**Objet : Site Plan Control Application: 925 Ralph Hennessy
File no. D07-12-18-0104**

As requested in the technical circulation comments letter, updated August 27, 2018, we are confirming the calculation for the school buses as a response to the planning comment number 13.

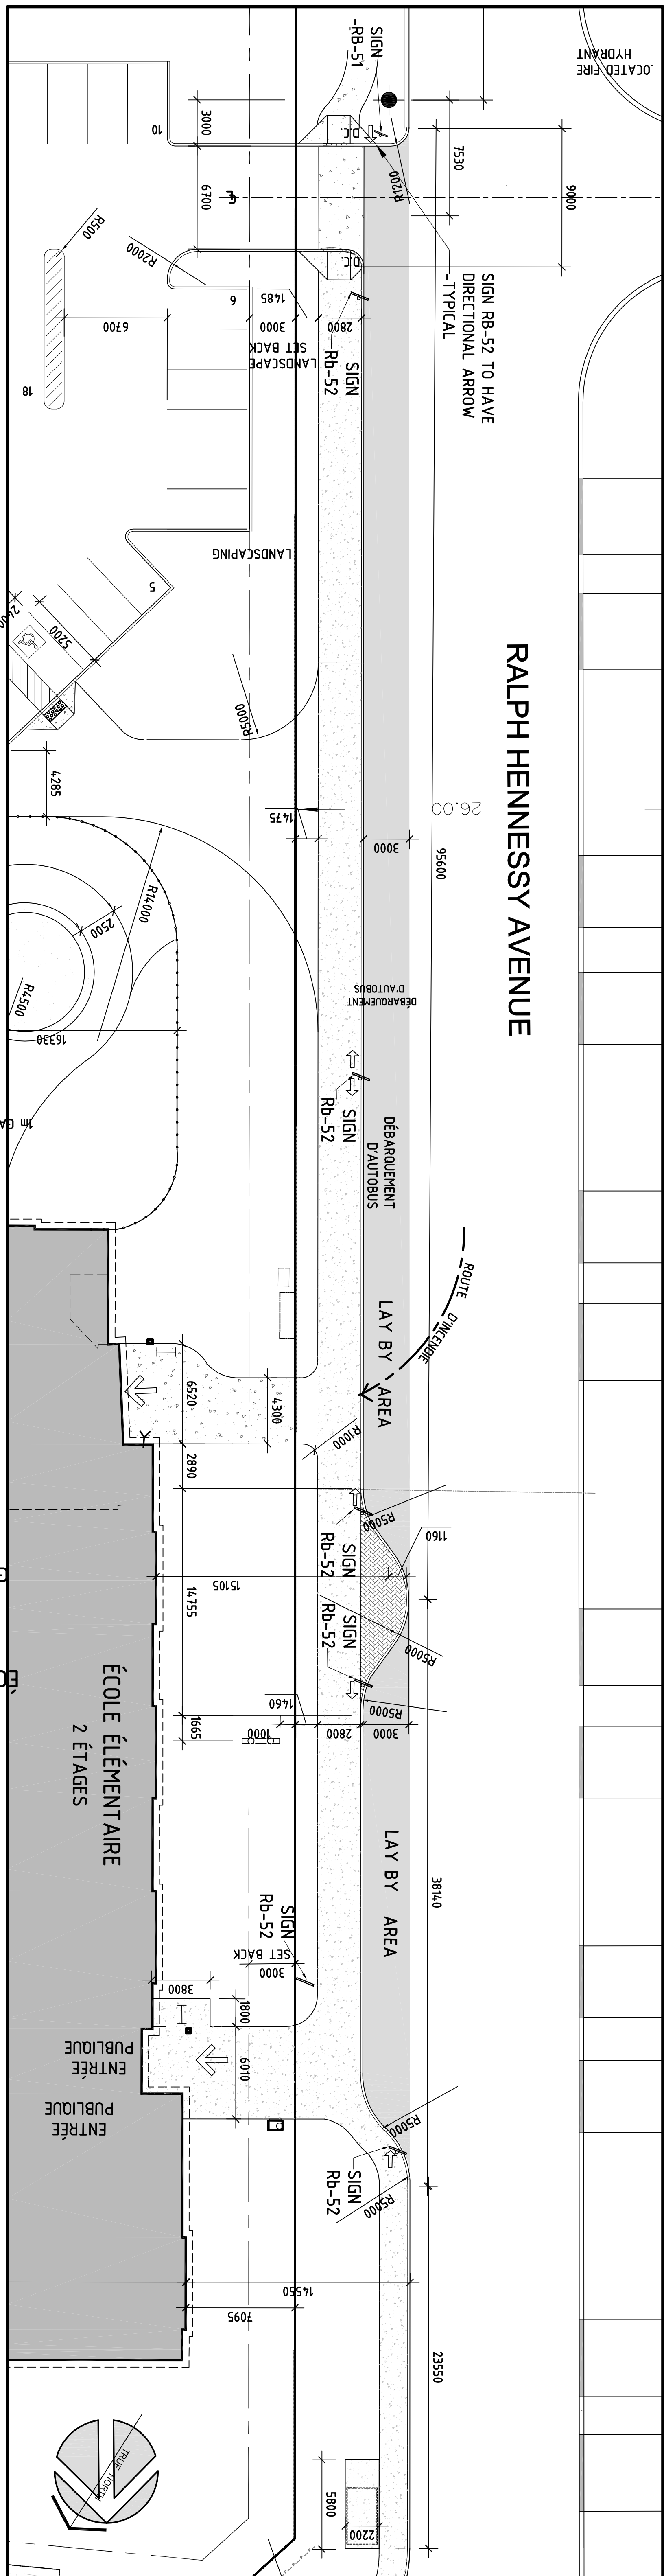
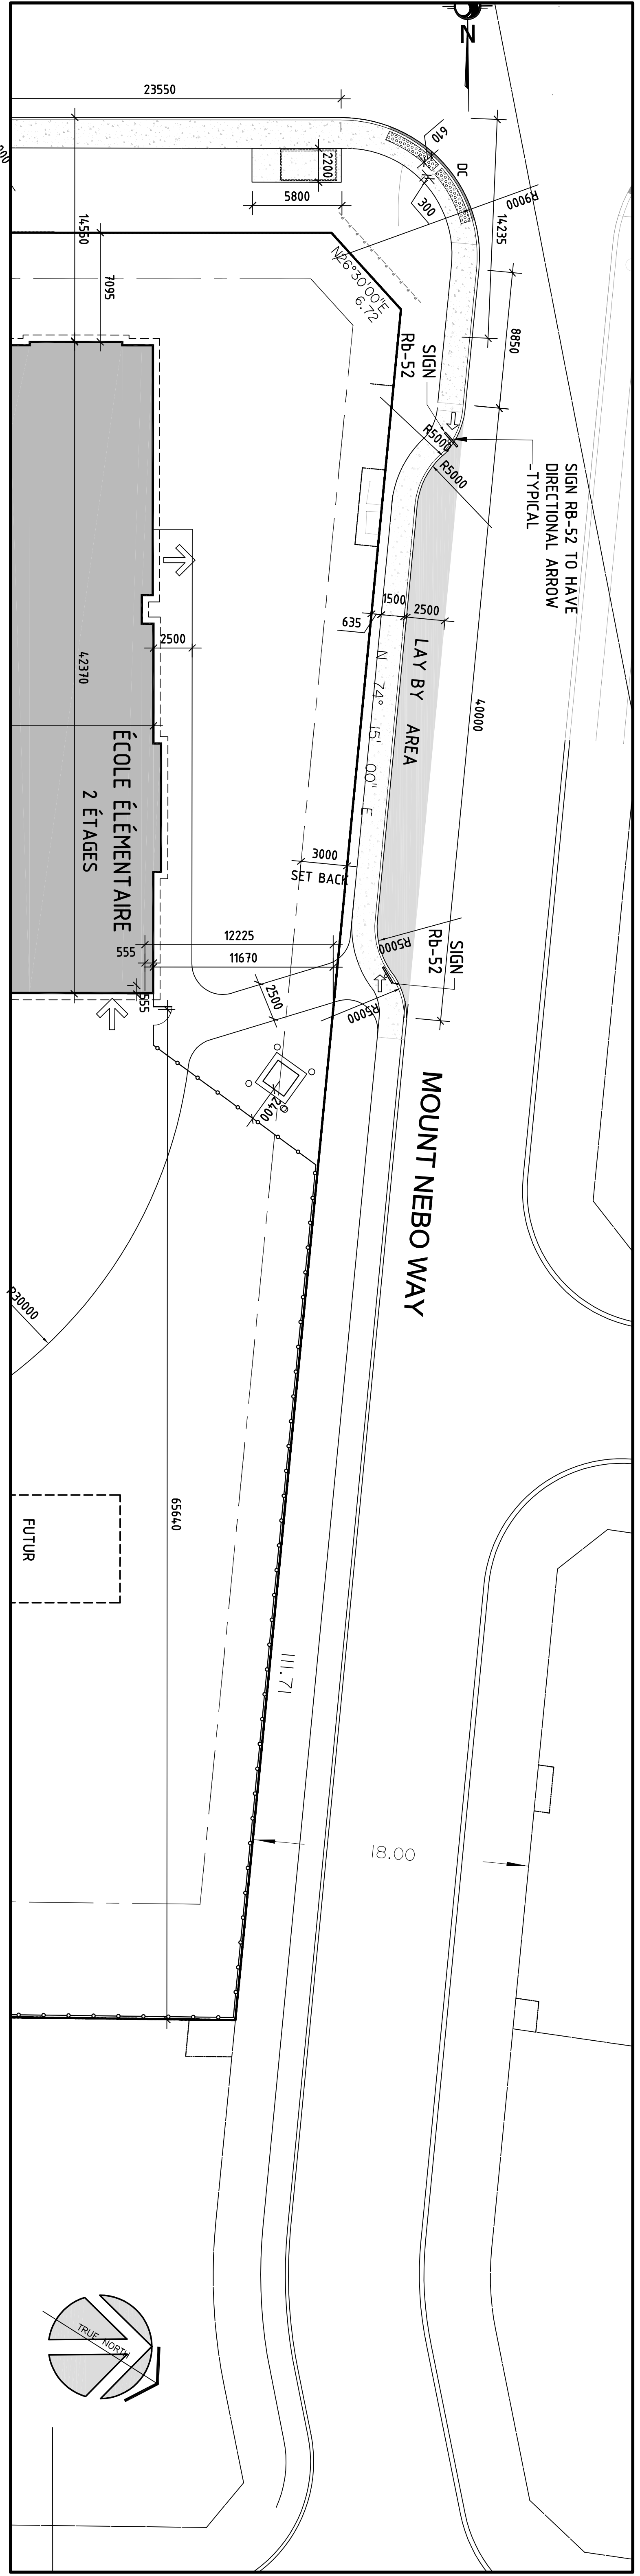
In the future, with an additional 4 classrooms, we would have a total of 481 students. At this point, we would need at least a seventh bus.

The proposed bus layby on Ralph Hennessy Avenue is design to accommodate six (6) buses. The school is design for around 389 children. Six buses are enough to transport all students. We anticipate that the school will be occupied at 60% in August 2019 and would become full in the future when the surrounding neighborhood develop.

To accommodate all children in the future, we propose to modify our site plan by extending the bus layby northwards on Ralph Hennessy to accommodate two more buses.
